13 December 2017

## **SSD 8334 -CONSTRUCTION OF A SCHOOL AT 120 -126 HEZLETT ROAD, KELLYVILLE**

I refer to the above development and the Department of Planning letter dated 25 October 2017 that provided advice on the Response to Submissions that had been received to the project as well as providing advice on the Departments preliminary assessment of the application.

STORMWATER DRAINAGE PLAN

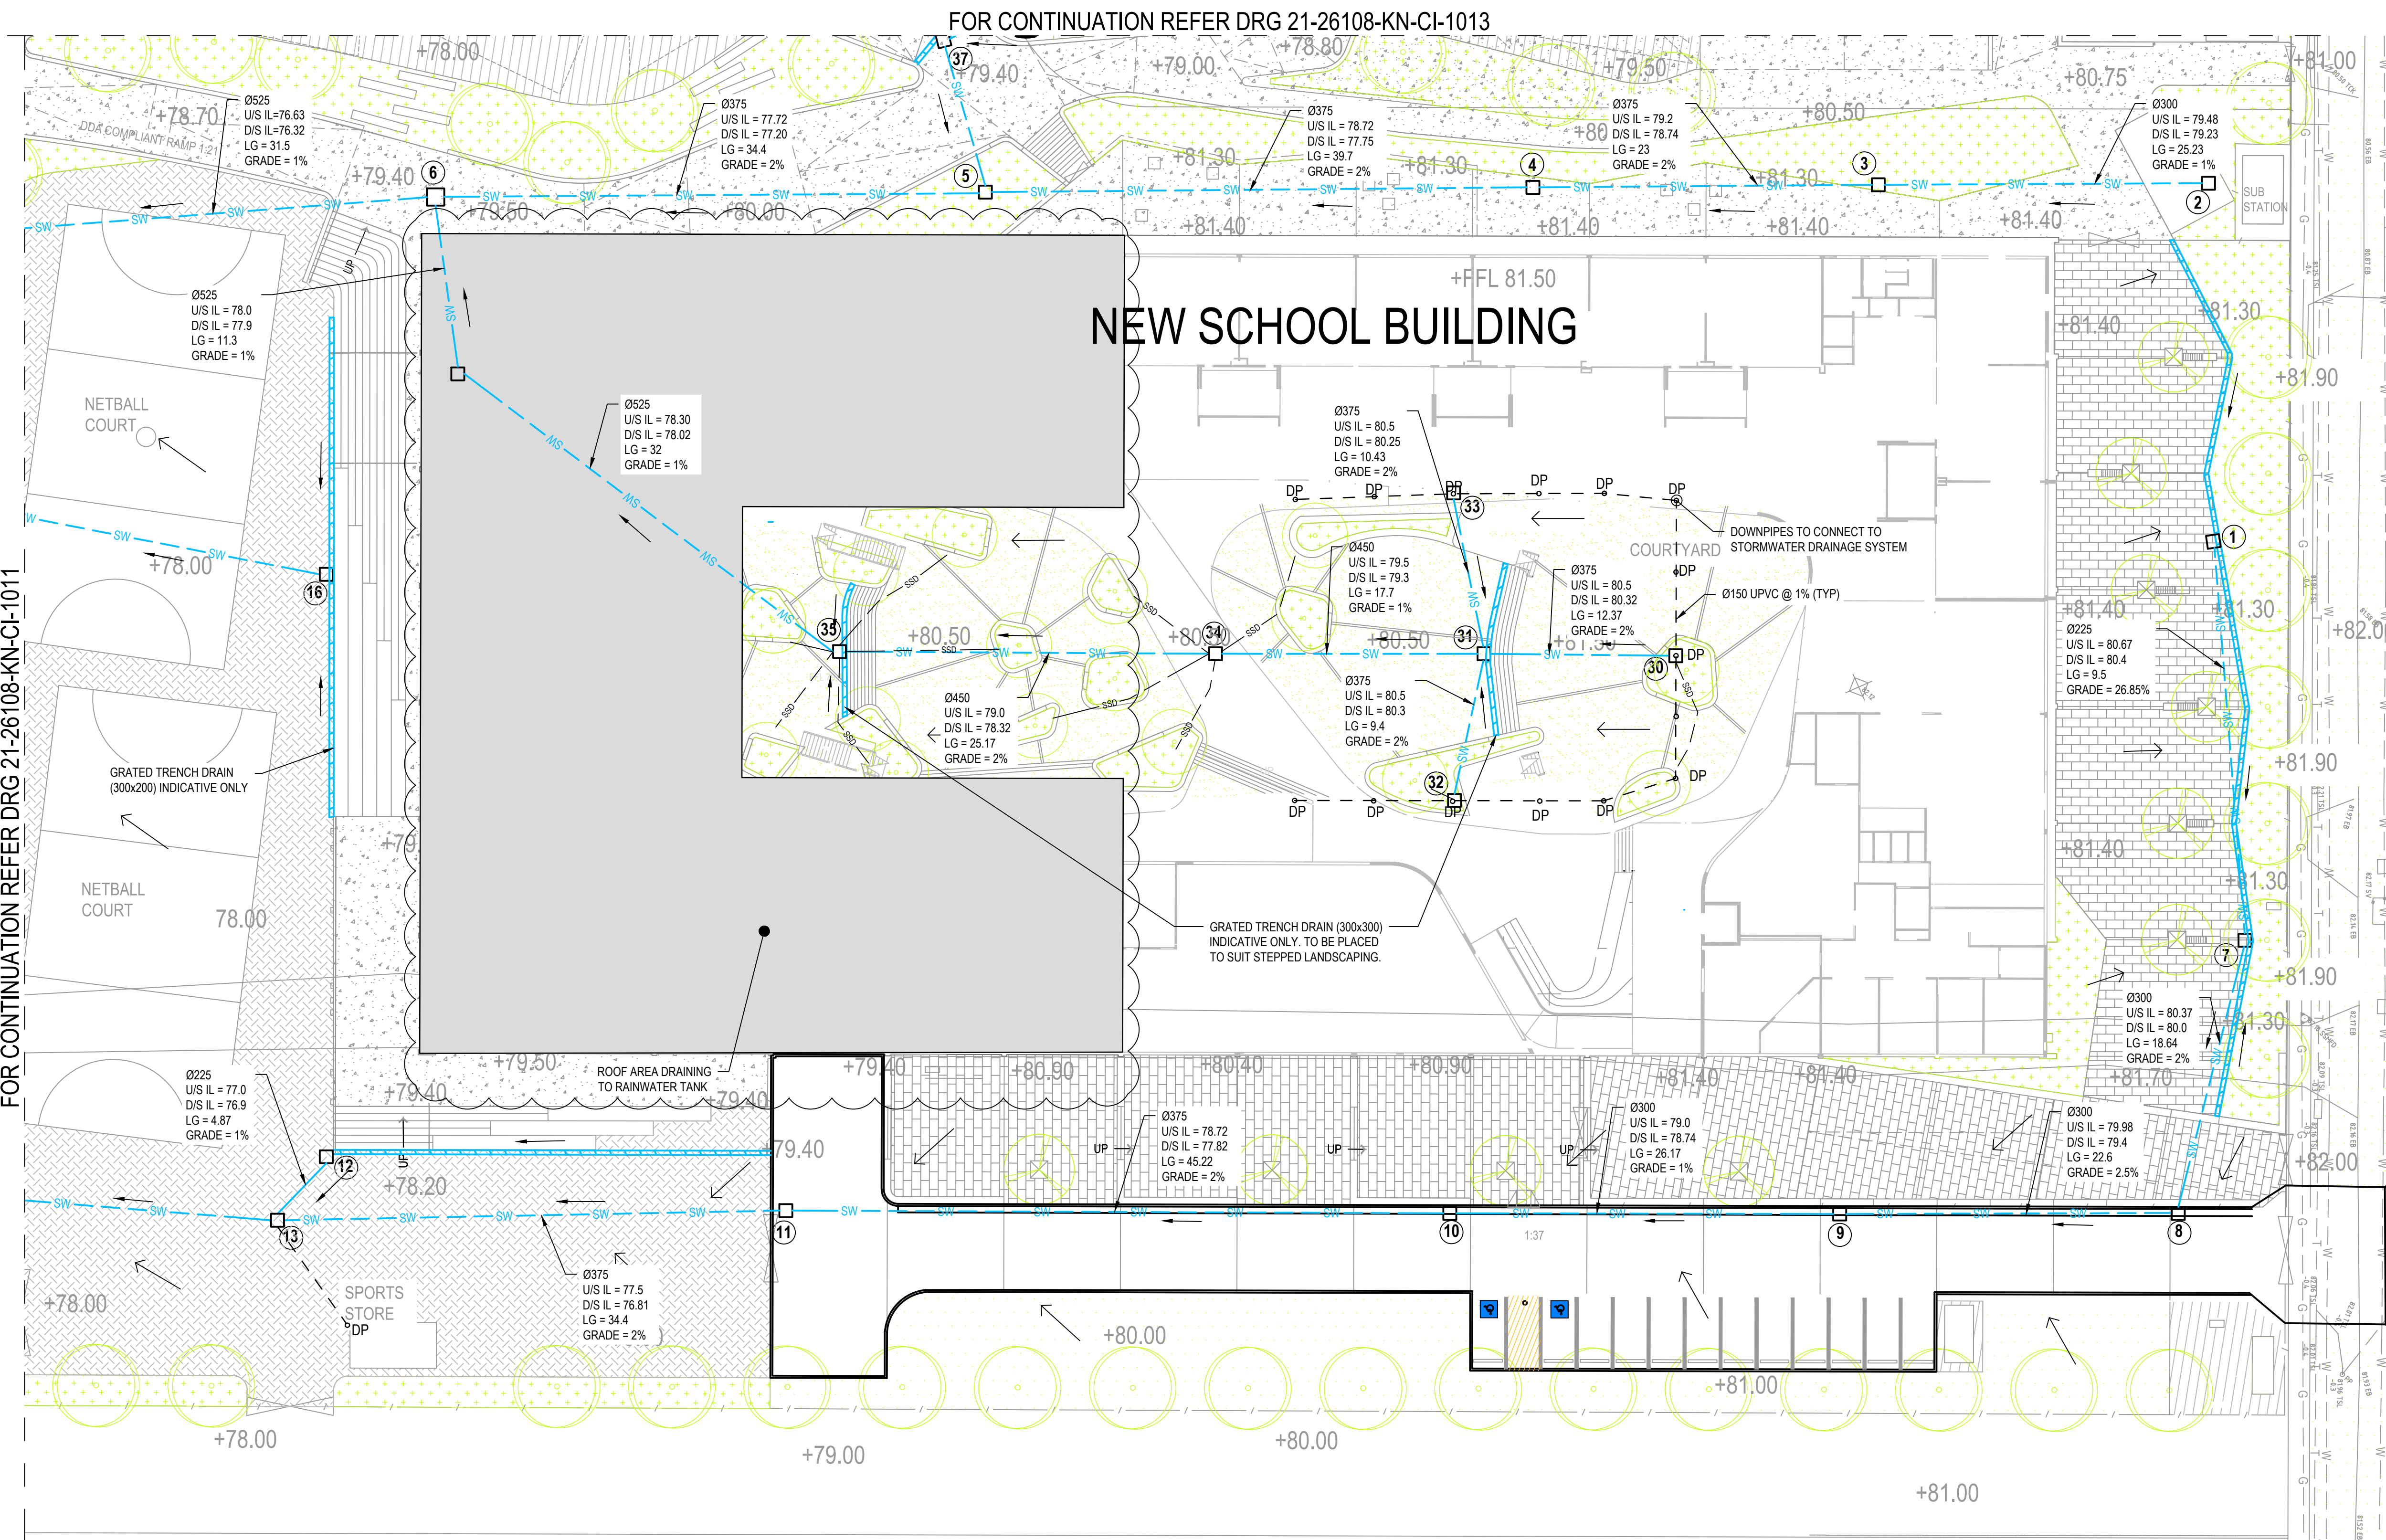
*The stormwater plan shows runoff being directed to an existing pit on the opposite side of Hipwell Avenue some 30m away from the site. The plan shows this private line crossing not only the existing public road but the adjoining private property and is obviously not supported. The existing street drainage in Hipwell Avenue will need to be extended south to the subject site, where an appropriate connection must be made. This is linked to the fact Hipwell Avenue itself has not been dealt with (see above). The existing pits and pipes need to be identified via survey and reflected on the plans to show that the pipe sizes and levels included on the design will actually work.*

*The stormwater report and the stormwater plan do not indicate a size for the proposed rain water tank which is located away from the actual building. It is not clear what roof areas actually drain to this tank.*

The updated hydraulic plans include in the design plans to address and show further information on the levels and connection to the known existing Council network.

The proposed rainwater tank has a capacity of 22.5m<sup>3</sup>. The updated hydraulic drawings illustrate the roof area that drains to the tank.
